PROPOSALS FOR  
**WHINNEY CLOSE FARM**  
COCKLEY HILL LANE, KIRKHEATON,  
YORKSHIRE  
SPECIALIST DESIGN REVIEW COMMENT

December 2024

drawing title **PROPOSED ELEVATIONS**

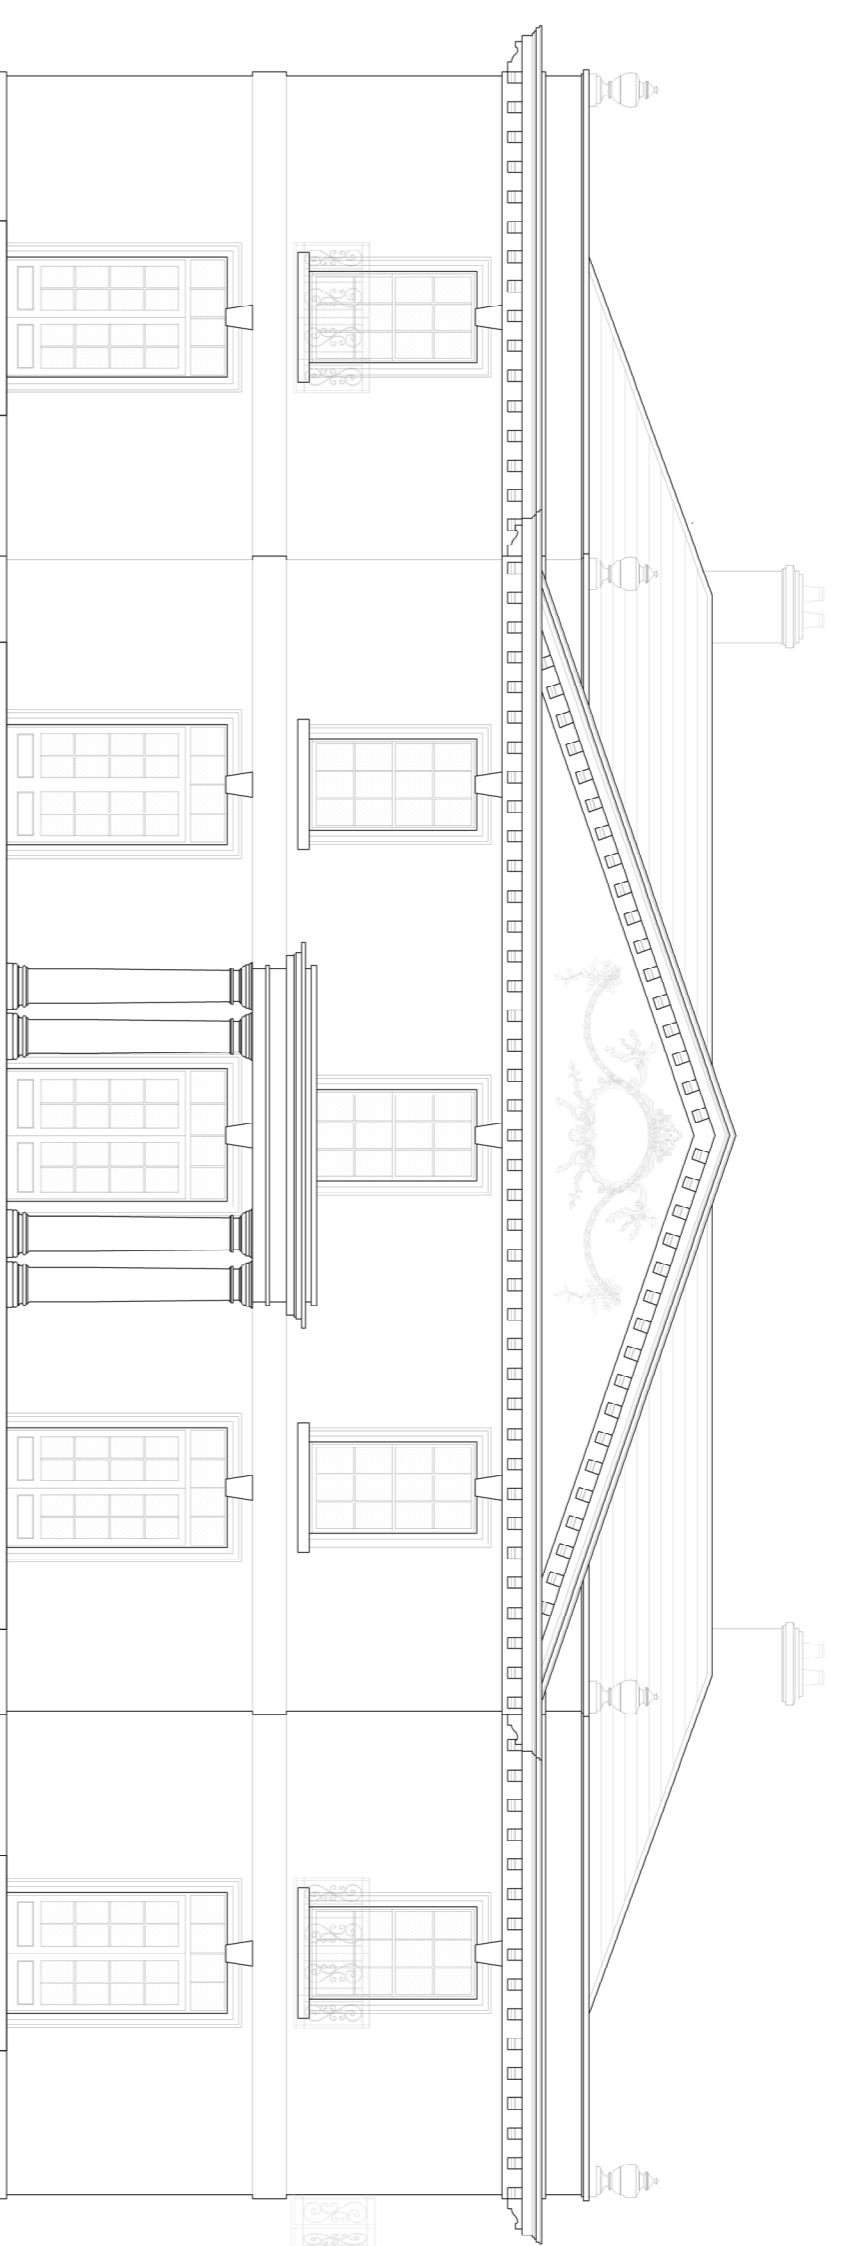
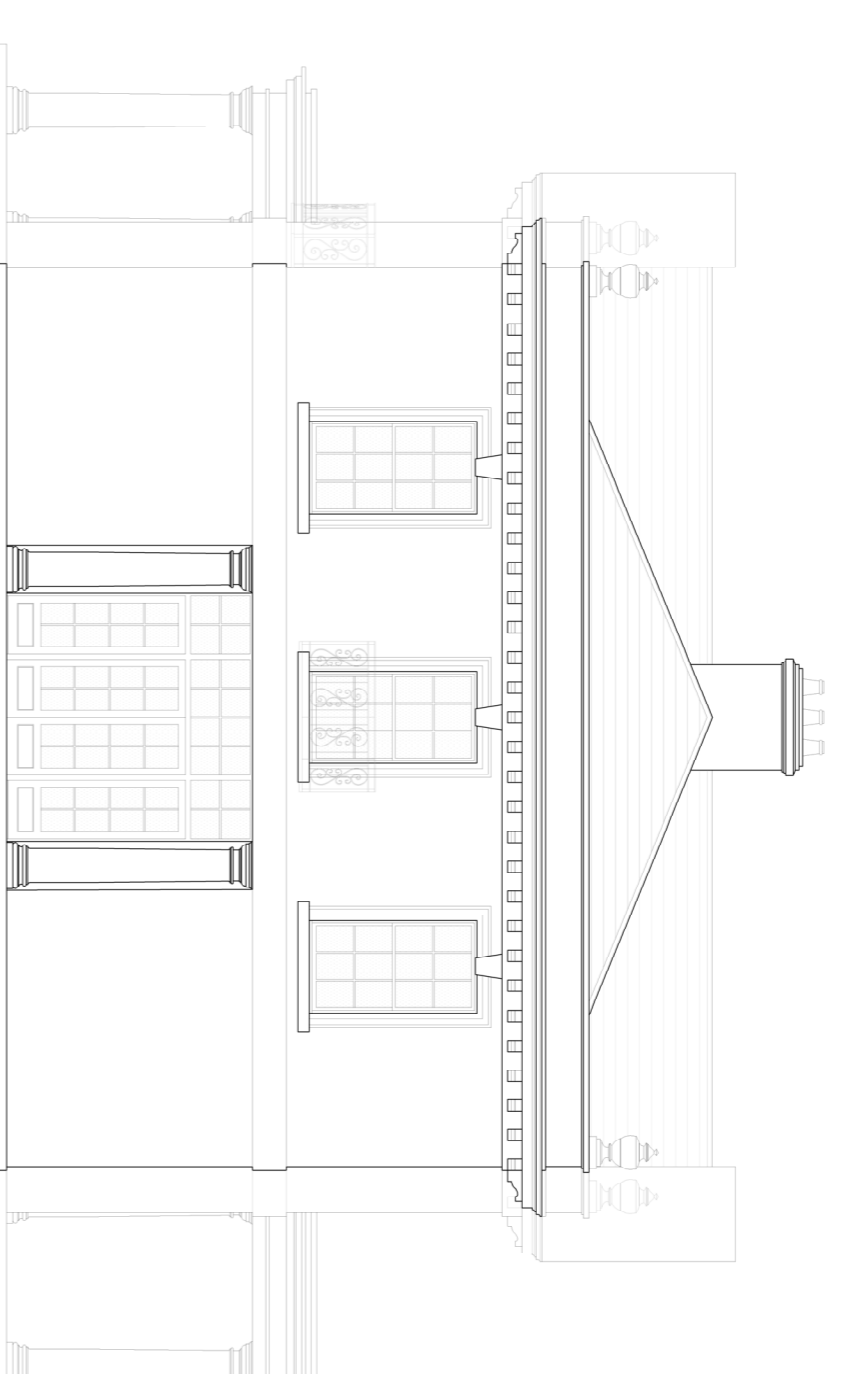
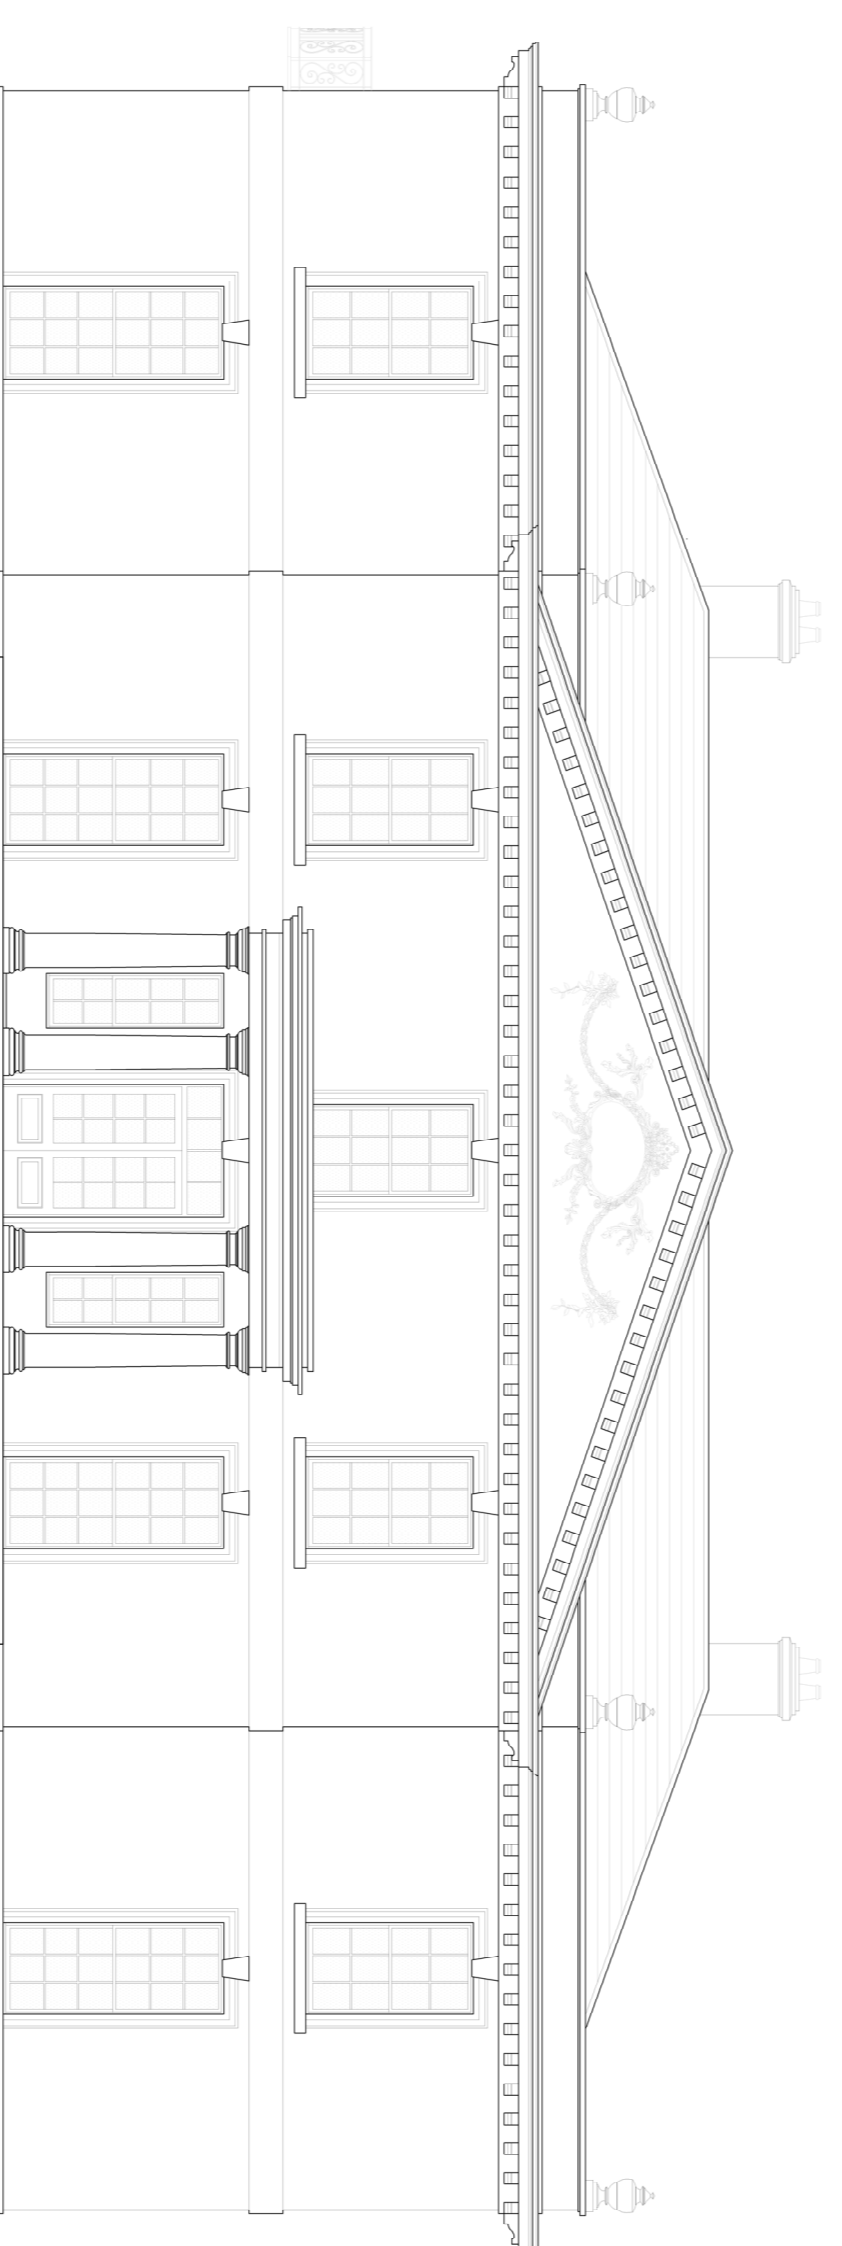
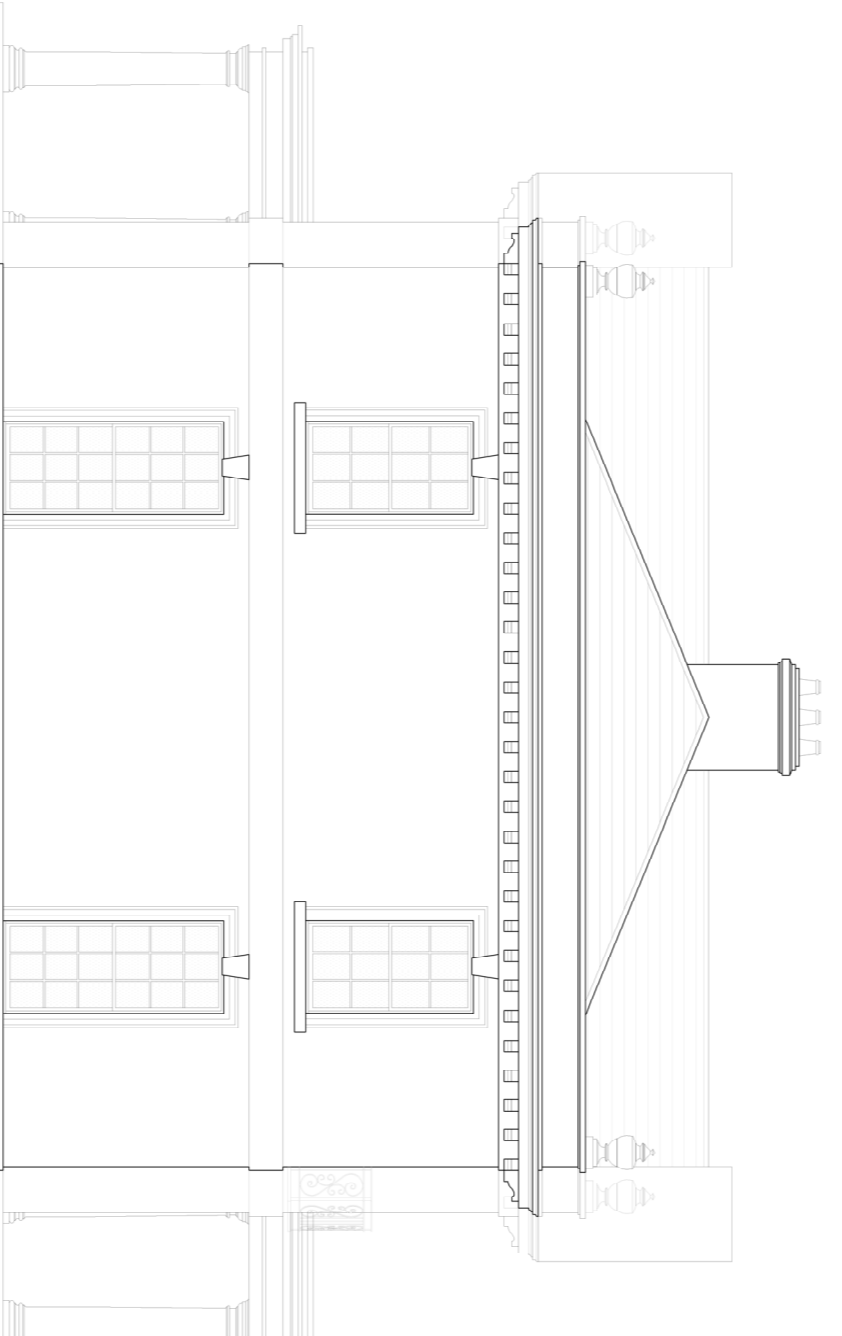
- The example of John Carr-designed 1770s Middleton Lodge was chosen by the designer to inform the design of this new house, as it was a later eighteenth-century house which has the principal rooms on the ground floor, not raised on a piano nobile, and therefore provided a suitable model for a new two-storey house. It is noted that the proposal adheres to the local authority's rule of not exceeding the existing ridgeline, however it seems to me that the design would benefit from a slightly more generous proportion for the very best architectural effect.

1. The existing house on this site is a degraded farmhouse, of no special significance, and the case is well made for its replacement. The proposed new house follows largely the footprint and ridgeline of the existing house – although it could be argued a slightly higher ridgeline would make for an even more sophisticated and better proportioned design.
